Appendix A – Response to Submissions Table

This Appendix provides a detailed summary of the Applicant's response to the issues raised in submissions to SSD-80211463.

Table 1 DPHI RTS Response

Figure 5: Proposed Building Height Comparative to the Height Plane (Breach)

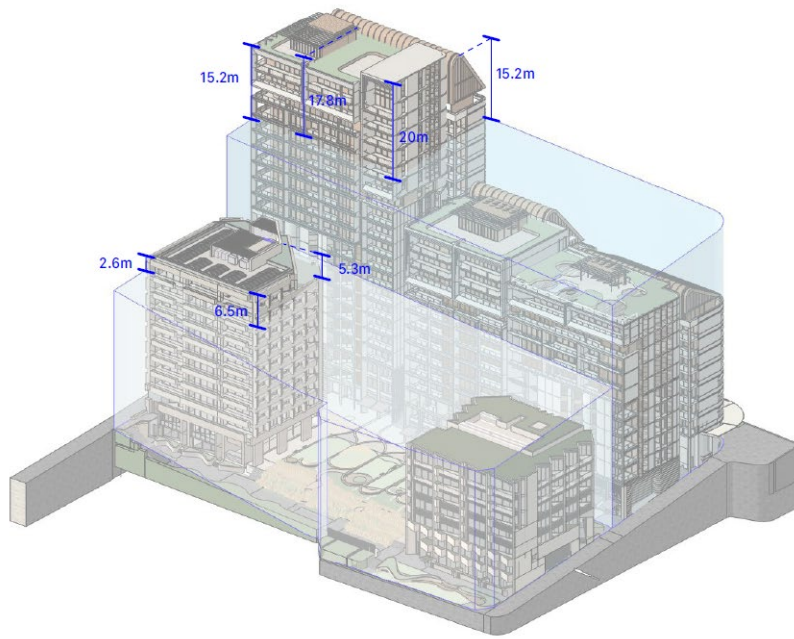
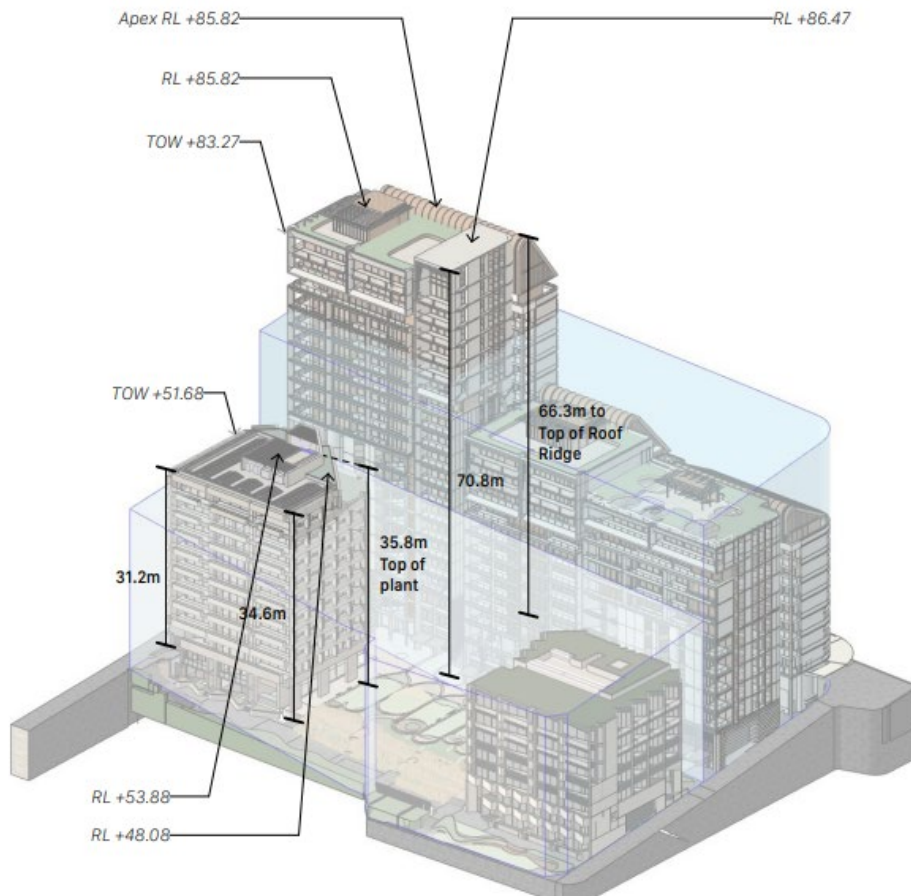
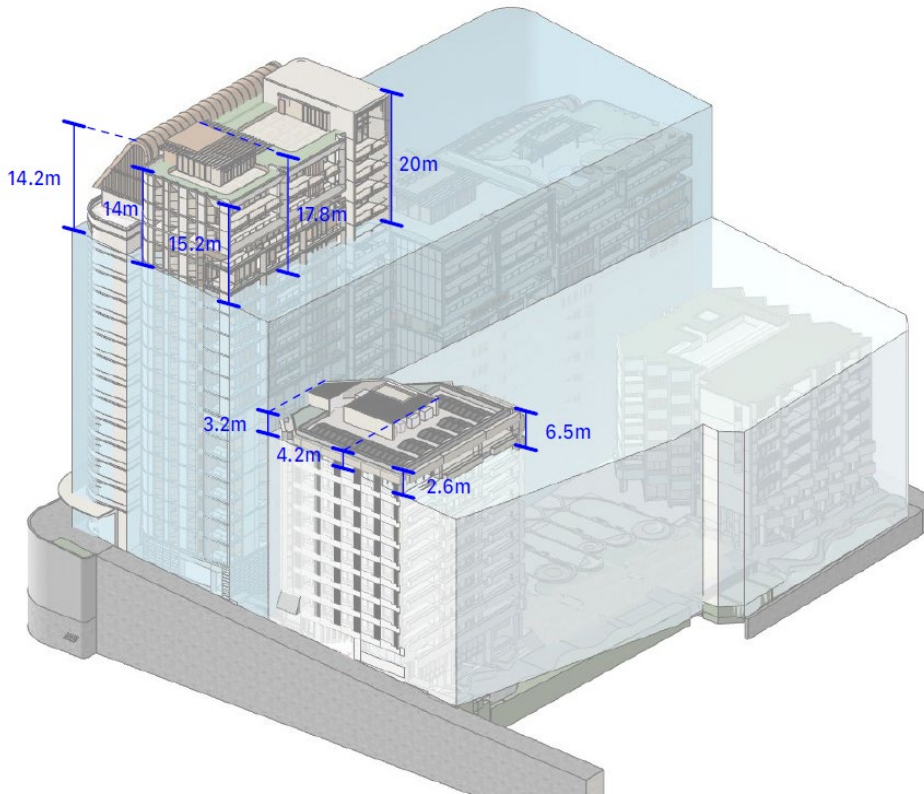
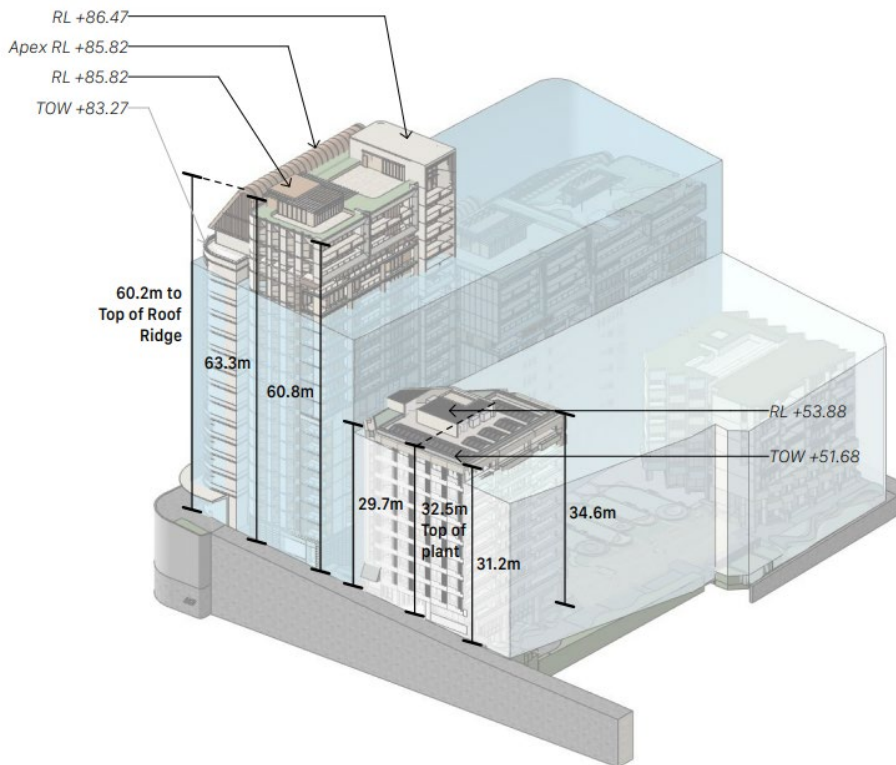
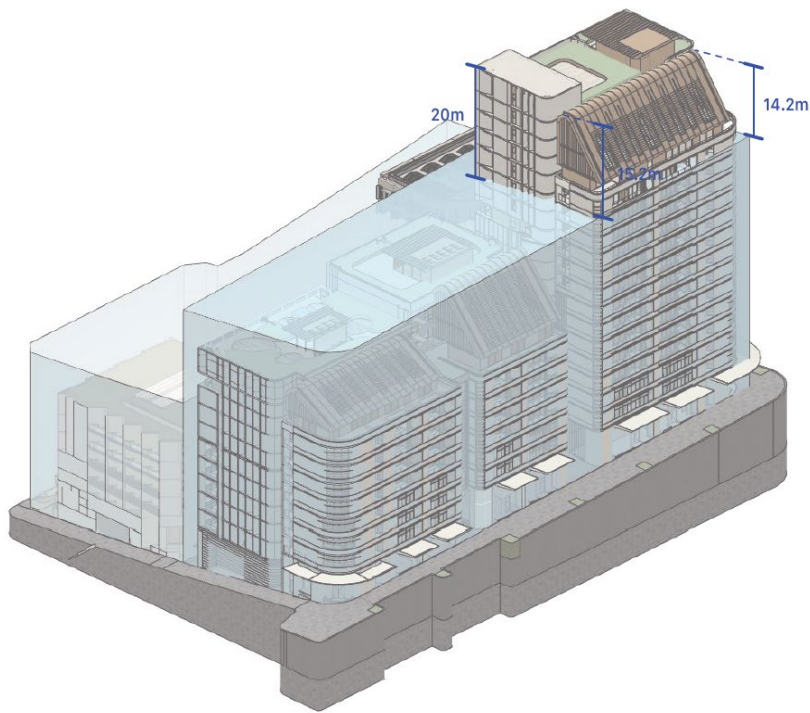
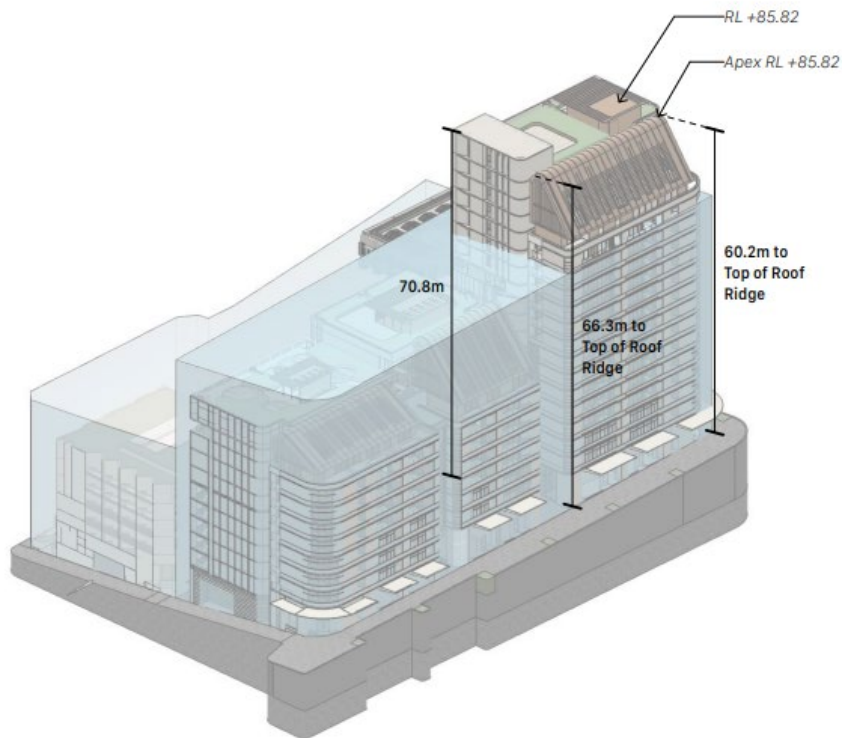
27	<p>Provide revised Clause 4.6 variation requests for building height and FSR having regard to the following:</p> <p>a. updated numerical figures which are consistent across both variation requests (in body of text and in diagrams), including, critically, in the quantum of variation sought under each request.</p>	<p>The amended Clause 4.6 Variation Requests have been updated to reflect the amended architectural plans.</p>	<p>Refer to updated Clause 4.6 Variation Request (FSR) at Appendix J.</p> <p>Refer to updated Clause 4.6 Variation Request (Height) at Appendix I.</p>
28	<p>b. each request clearly set out the variation percentage sought for each development standard and provide a correct visual representation of the variation sought under each development standard.</p>	<p>The amended Clause 4.6 Variation Requests have been updated to reflect this.</p>	<p>Refer to updated Clause 4.6 Variation Request (FSR) at Appendix J.</p> <p>Refer to updated Clause 4.6 Variation Request (Height) at Appendix I.</p>

Client: WILLIAM STREET NOMINEE PTY LTD
Drawing the PLAN OF DETAIL AND LEVELS OVER LOT 1 IN DP 814050 AND LOT 52 IN DP 1049805, KNOWN AS No.166-194 WILLIAM STREET, WOOLLOOMOOLOO

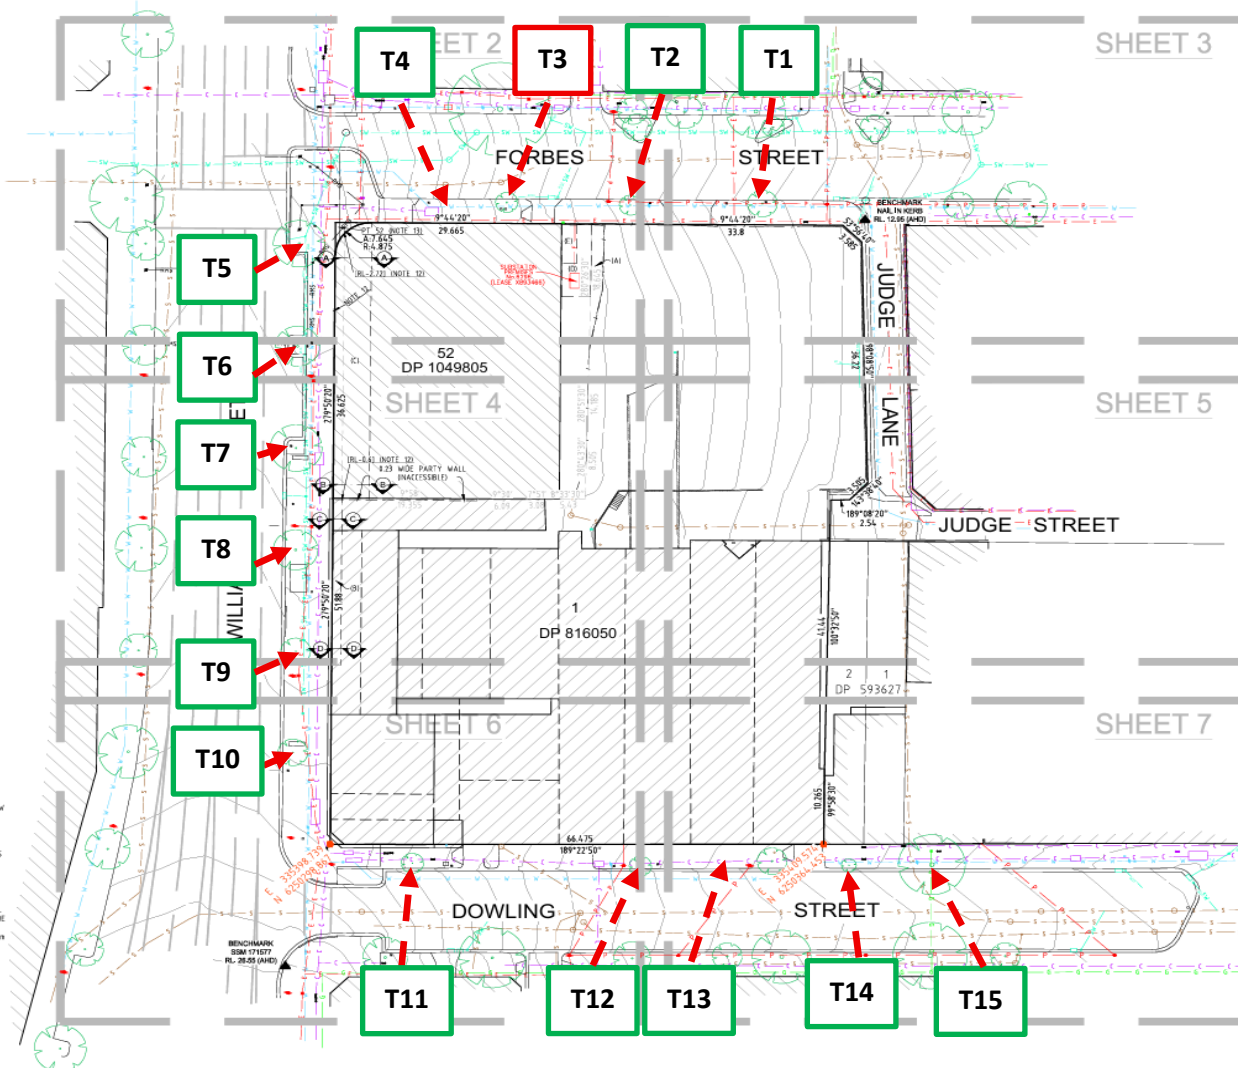
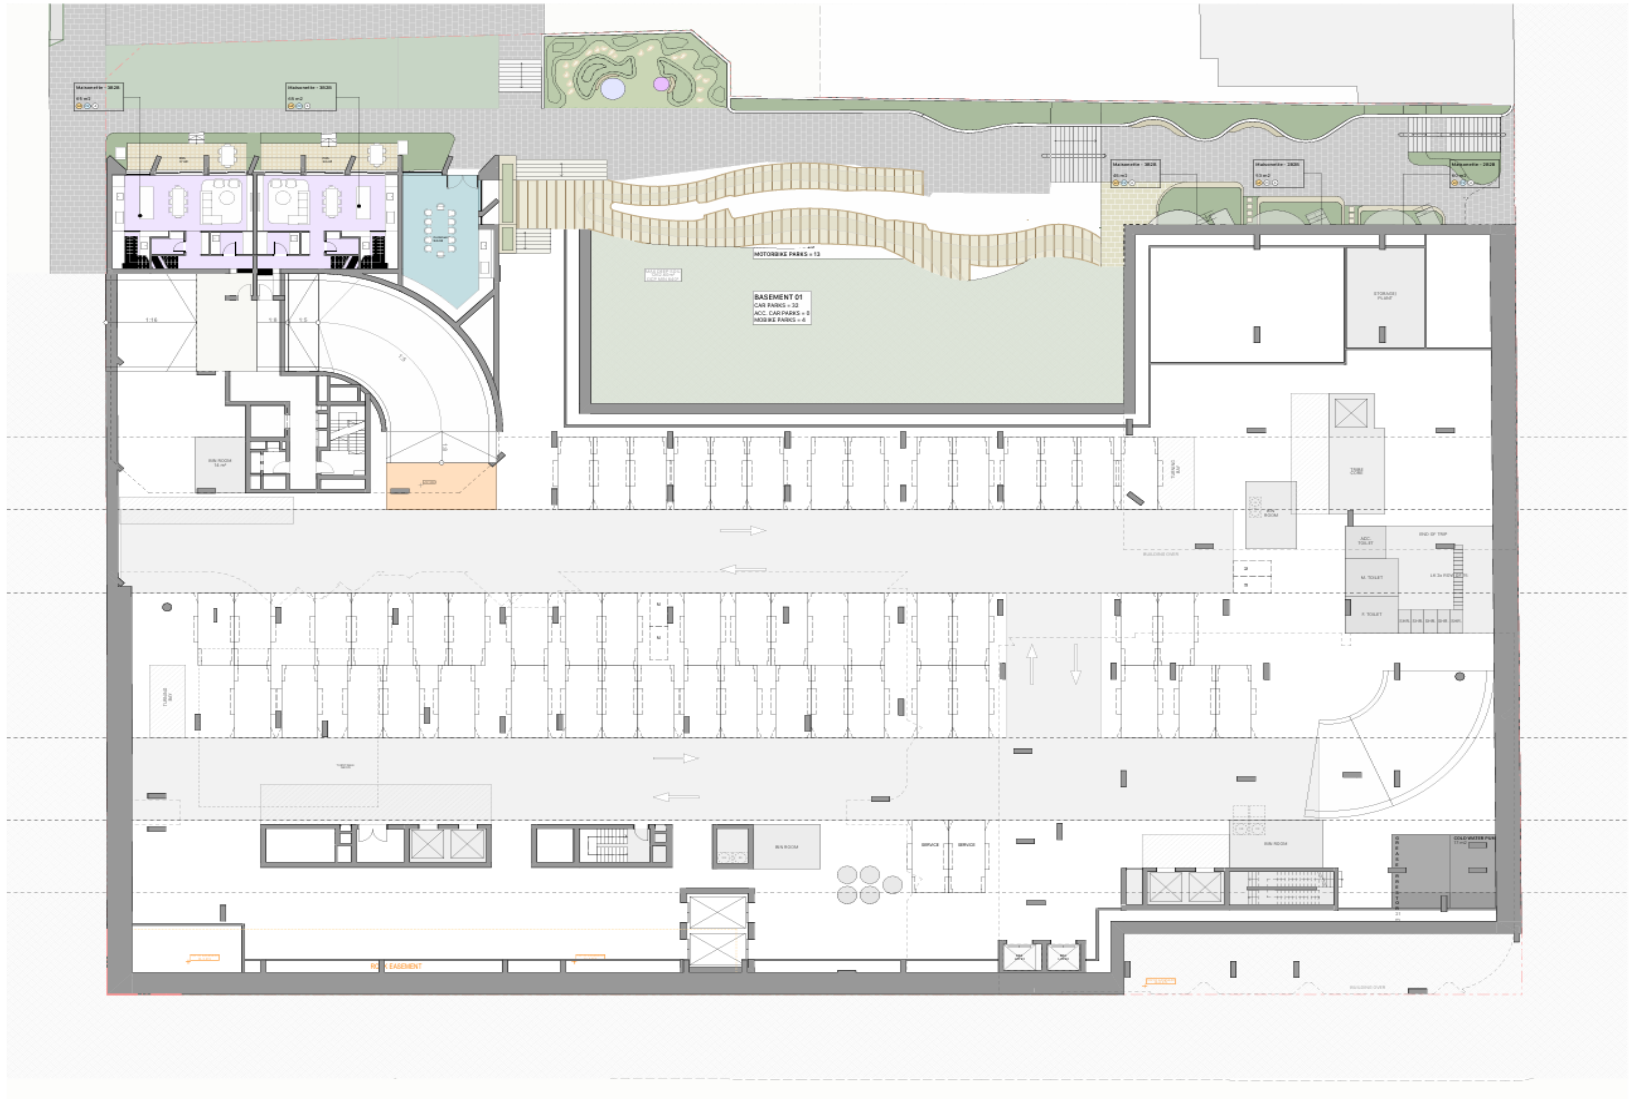
49	<p>a. Provide a revised site survey showing total site area and area by lot.</p>	<p>This has been provided as part of the RtS Response.</p>	<p>Refer to Revised Site Survey Appendix L.</p>
50	<p>b. Further to recommendations in the Arborist Report, update the site survey to show the location of Tree 4 - Syzygium and Tree 13 - Liriodendron, as these trees are recommended to be retained.</p>	<p>This has been provided as part of the RtS Response.</p>	<p>Refer to Revised Site Survey Appendix L.</p>
